3 February 2021
 Our Ref: 2517 / DPIE Ref: SSI-9487

RE: Submission in relation to the Inland Rail – Narromine to Narrabri (SSI-9487)

Prepared by:	Jim Lawler, Associate, Groundwork Plus Pty Ltd PO Box 1779, Milton BC QLD 4064 P: 07 3871 0411, M: 0406 680 969, E: jlawler@groundwork.com.au
On behalf of:	Regional Quarries Australia Pty Ltd
In relation to:	Inland Rail – Narromine to Narrabri (SSI-9487)
Submission:	Objection
Reasons:	<ol style="list-style-type: none"> 1. Chapter C3 of the N2N EIS identifies exceedances of noise, vibration and air quality criteria for the operation of the borrow pits which would not ordinarily be acceptable for an Extractive industry. 2. The N2N EIS has not considered whether dust from the resource at the borrow pits could result in a human health risk for respirable crystalline silica. 3. The borrow pits for the N2N should be held to the same assessment criteria and operational obligations as a commercial quarry operation. 4. The N2N has not considered the most likely haulage routes for quarry materials from existing quarries in Dubbo and should be revised to include an assessment of impacts of construction traffic on the Mitchell Highway, Tantitha Roa

Figure C3.4 Indicative layout - borrow pit D (Perimeter Road, Narrabri)

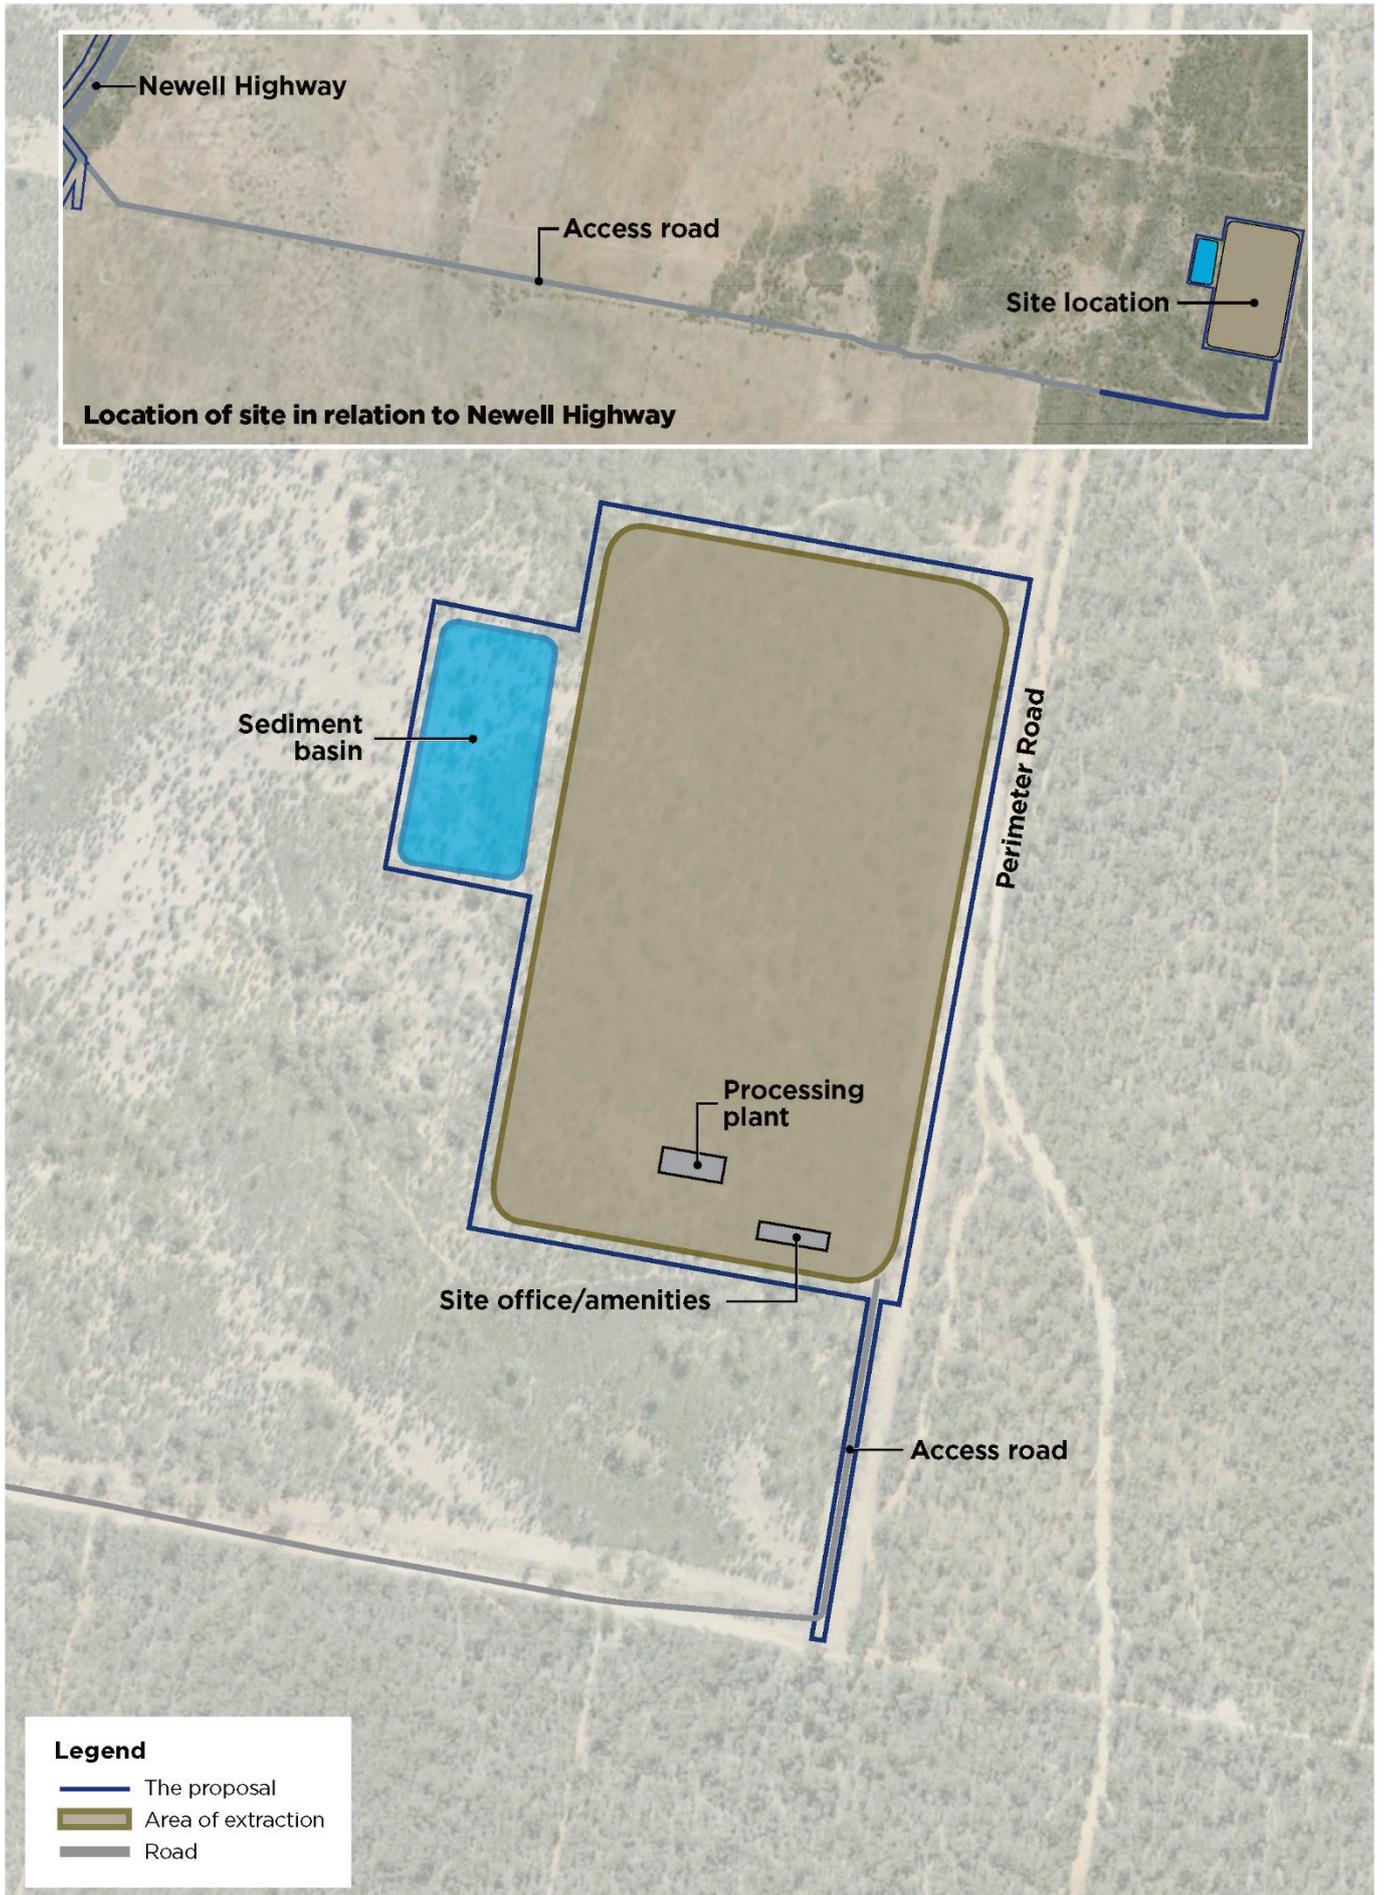
9. Borrow pit development plans are not sufficiently detailed.

The indicative layouts of the borrow pits provided in Chapter C3 of the N2N EIS do not provide the same level of detail ordinarily required for extractive industry. For example, a maximum depth of extraction is not identified, batters and benches of the extraction area are not identified and neither is the finished surface level. More detailed proposal plans should be provided to ensure adequate information is available to facilitate assessment of the potential impacts of the borrow pits and to assist in compliance investigations in the future.

Figure C3.5 Noise impacted receivers - borrow pit A

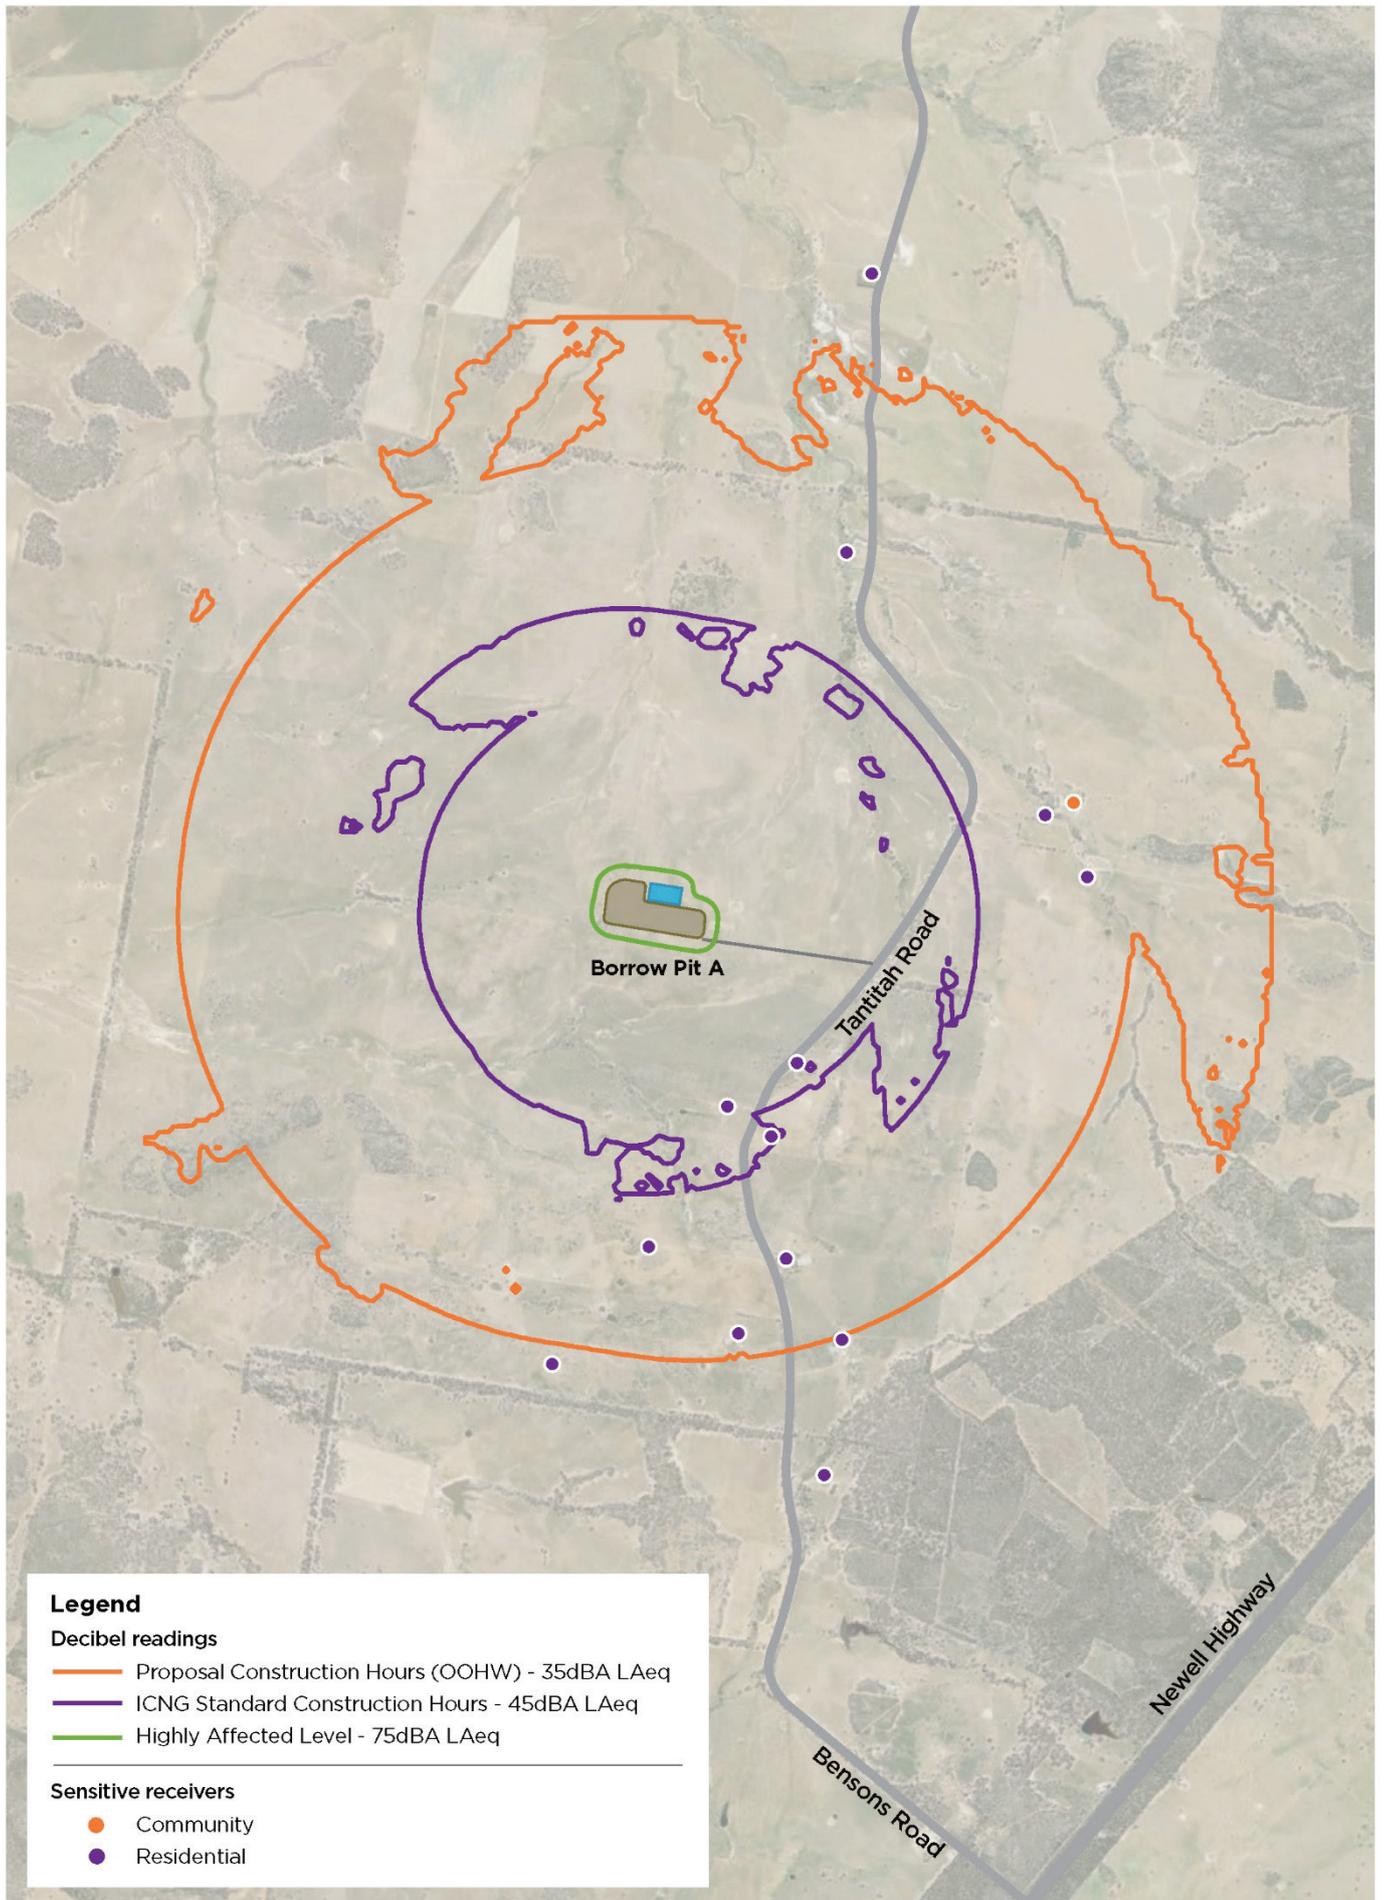
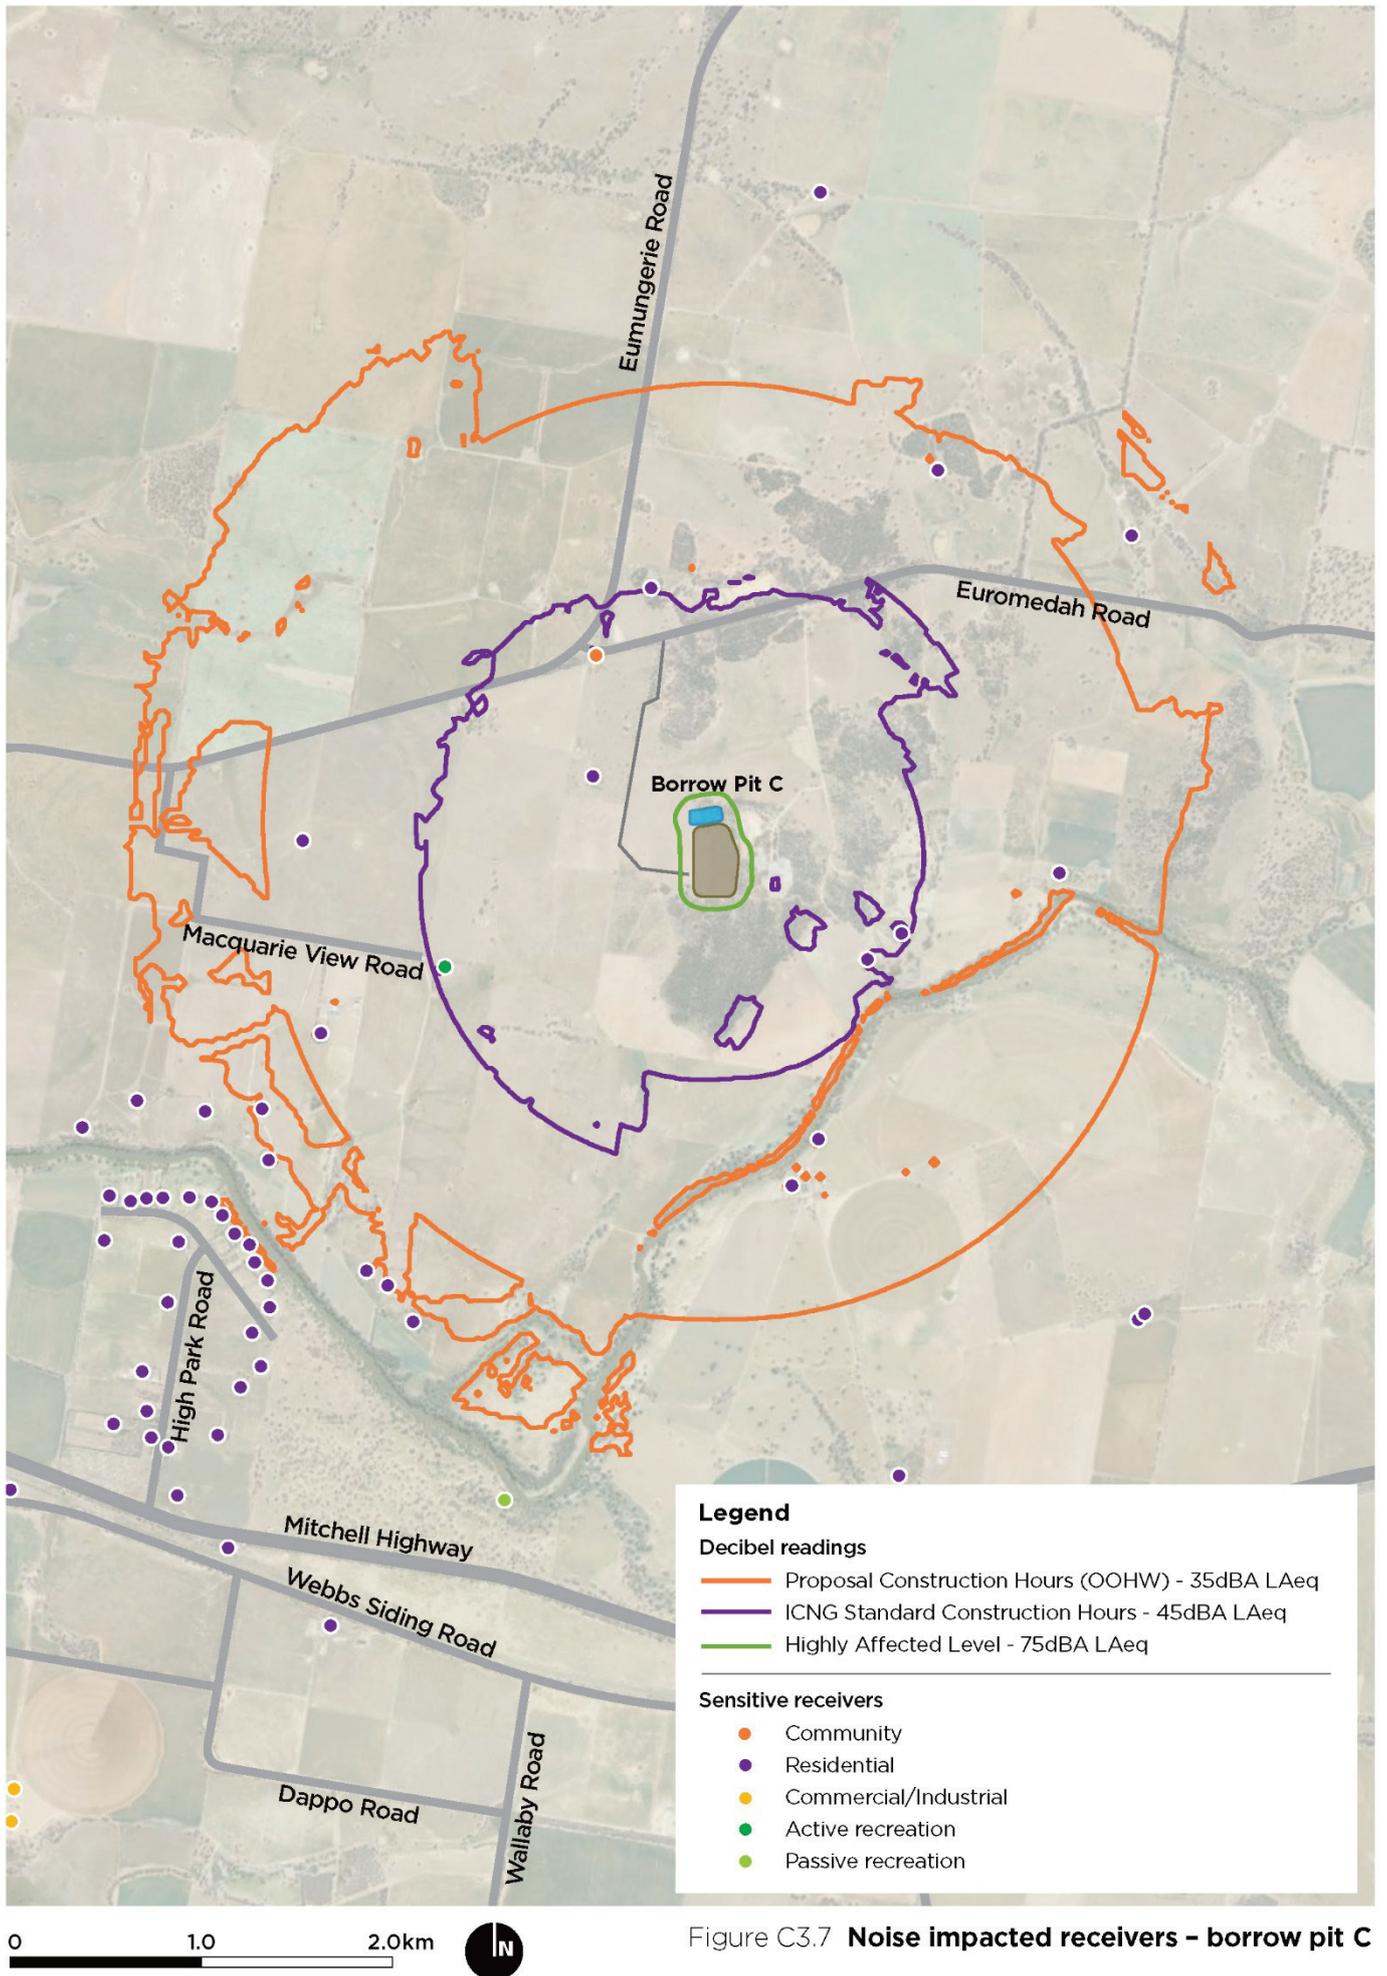
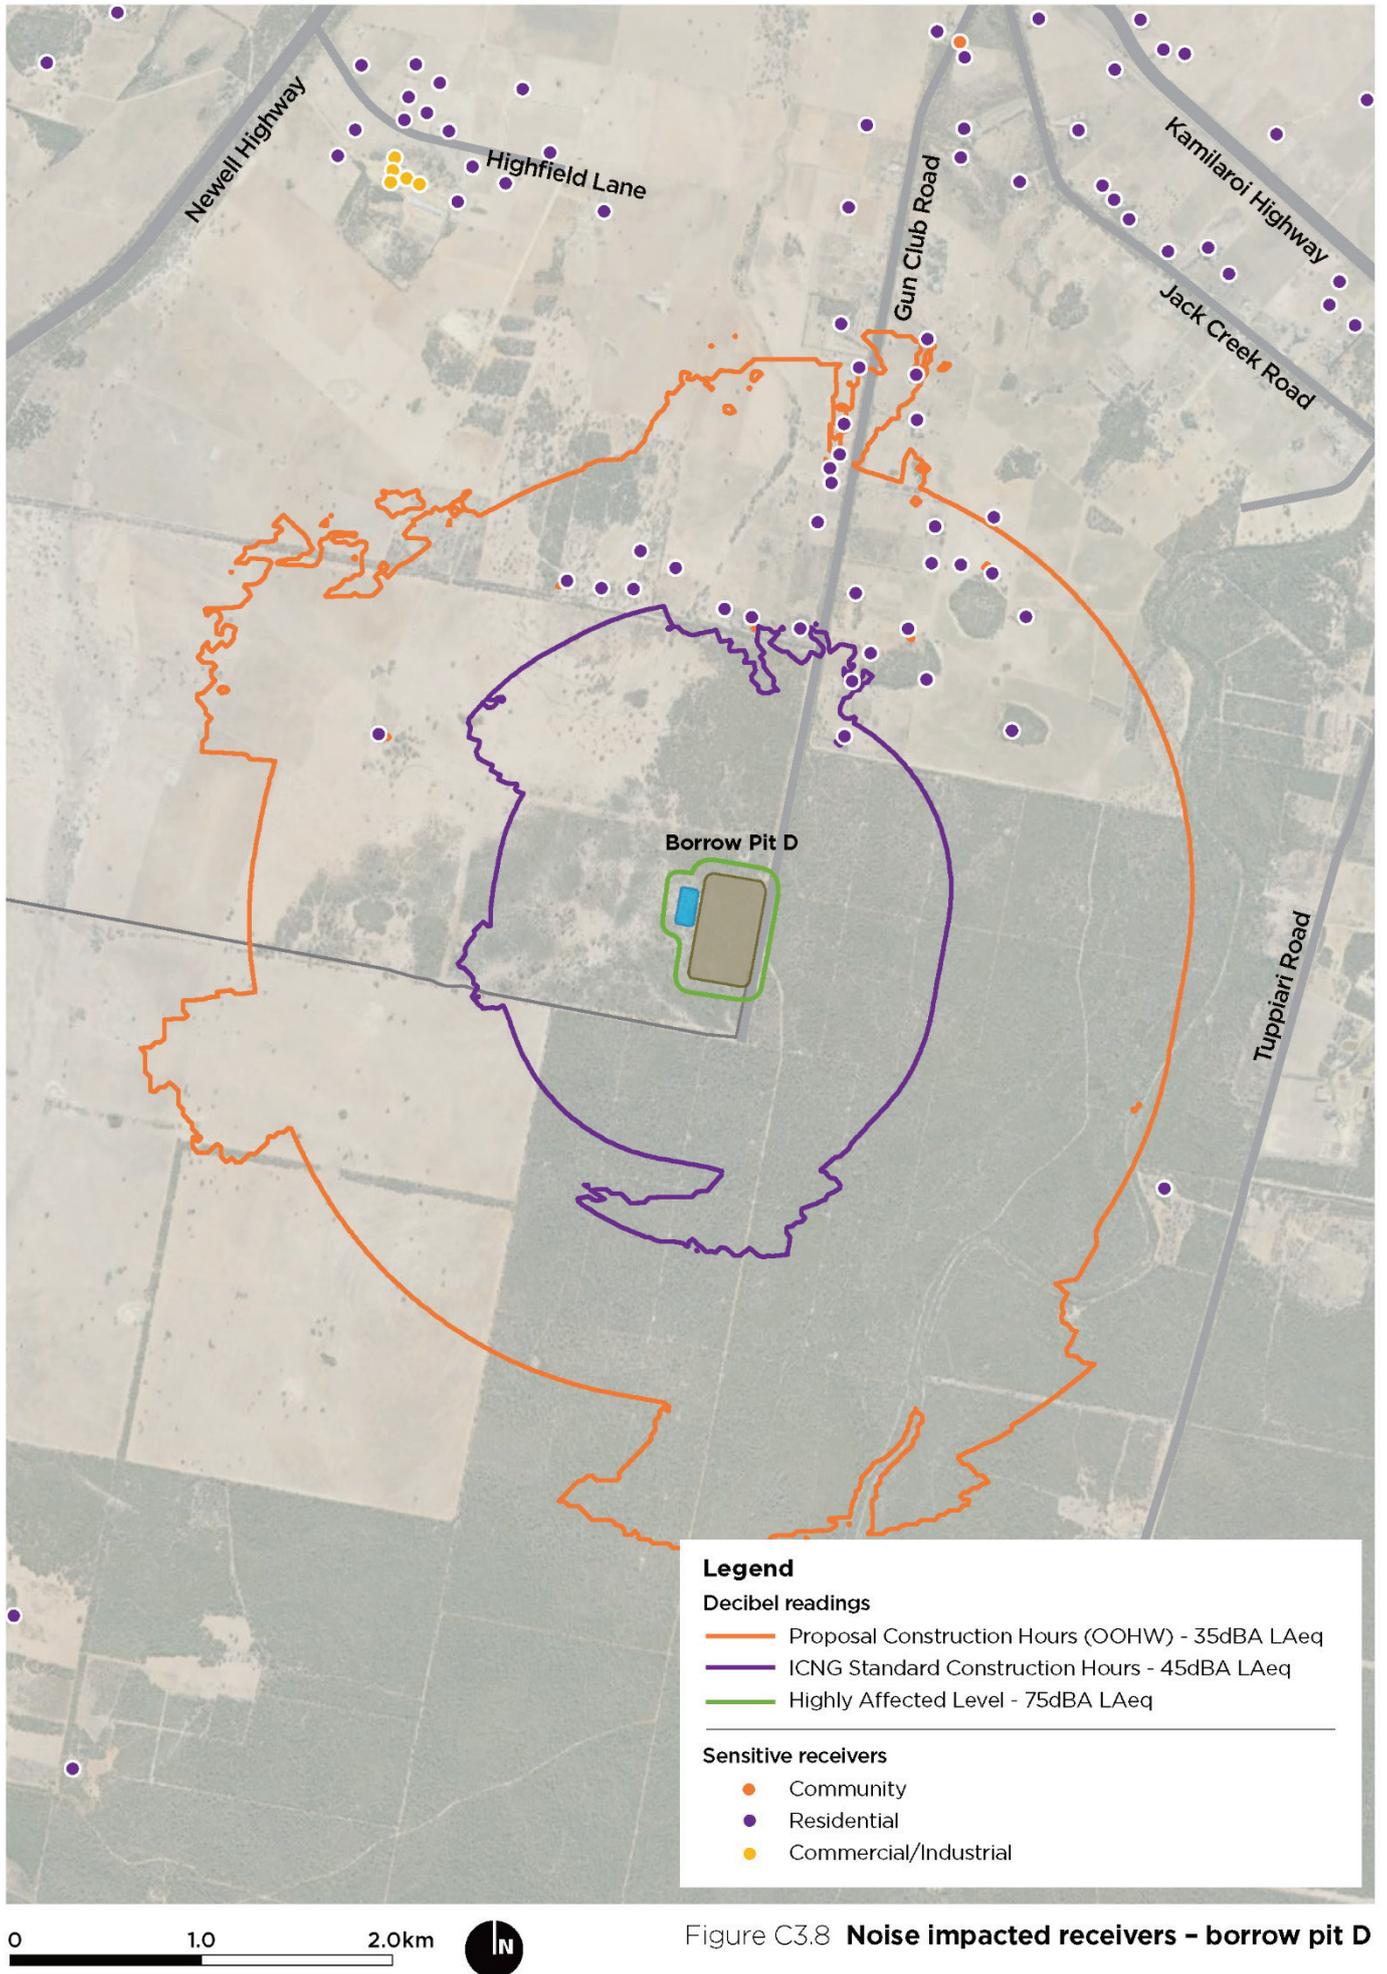
As shown in Table C3.6, during the use of the borrow pits, exceedances of the construction noise management level are predicted at a number of sensitive receivers, as follows:

- *Borrow pit A—at up to nine residential receivers during standard hours, up to two residential receivers during out-of-hours work and no non-residential receivers. **The highest level of exceedance predicted is up to 15 dB(A).***

- Borrow pit B—at up to 11 residential receivers during standard hours, one residential receiver during out-of-hours work and no non-residential receivers. *The highest level of exceedance predicted is up to 19 dB(A).*
- Borrow pit C—at up to 15 residential receivers during standard hours, one residential receiver during out-of-hours work and no non-residential receivers. *The highest level of exceedance predicted is up to 21 dB(A).*
